Town & Country Planning Act 1990 (as amended)
Town & Country Planning (Development Management Procedure) (England) Order 2015

Application for Planning Permission for Works or Extension to a Dwelling

Development: Ground Floor Extension. Two Storey Extension. Small Side Extension. Addition of Carport. Exterior materials change to render and cladding.
Location: 18 Manor Way Elmer Middleton-On-Sea PO22 6LA

LOCATION PLAN

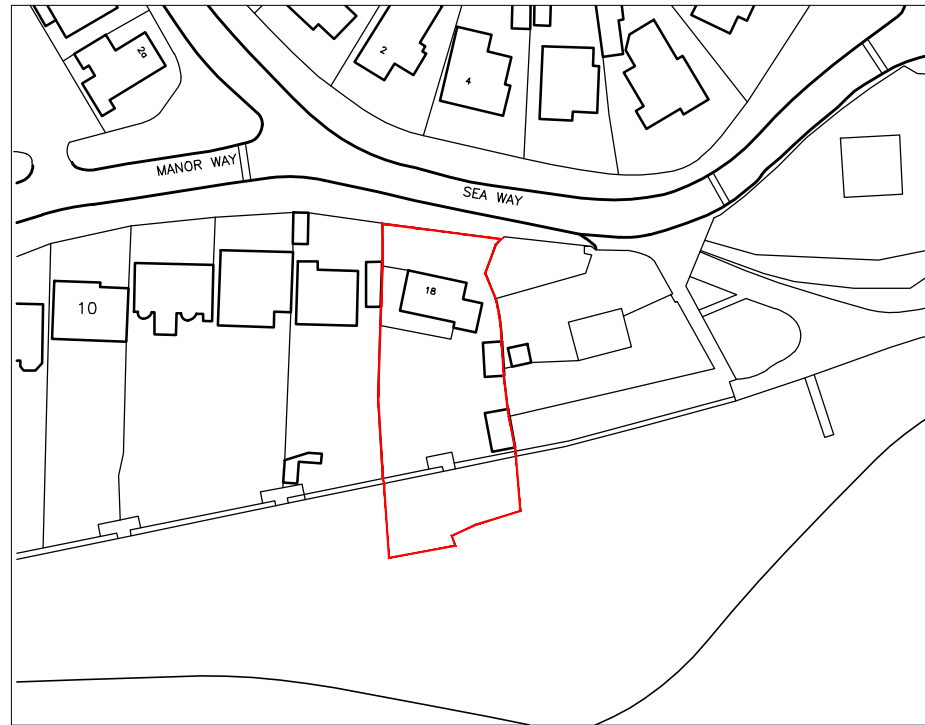
Location Plan

Please submit a copy of a location plan at a scale of 1:1250 or 1:2500 for rural areas. Further details of what must be included on the plan can be found in the Validation Requirements List.

LOCATION PLAN - 1:500

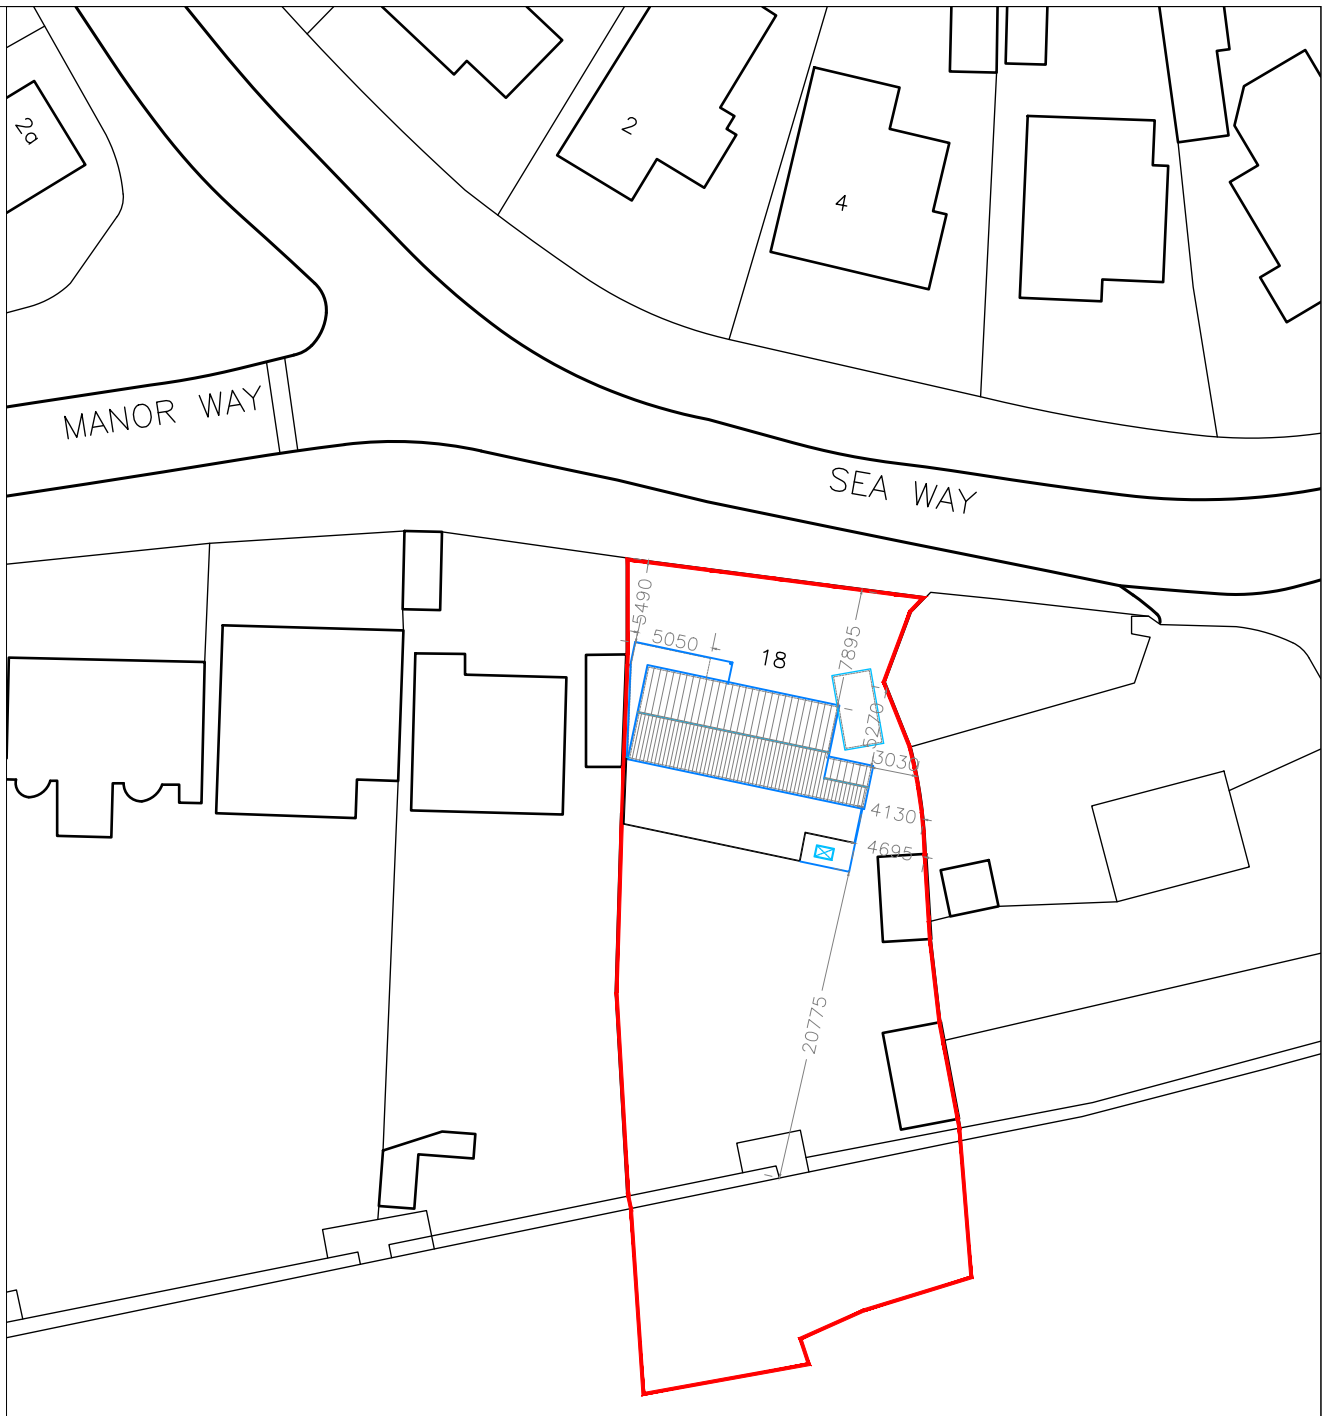
Block Plan

You are required to have dimensions from the proposed extension(s) to all site boundaries. Please amend.
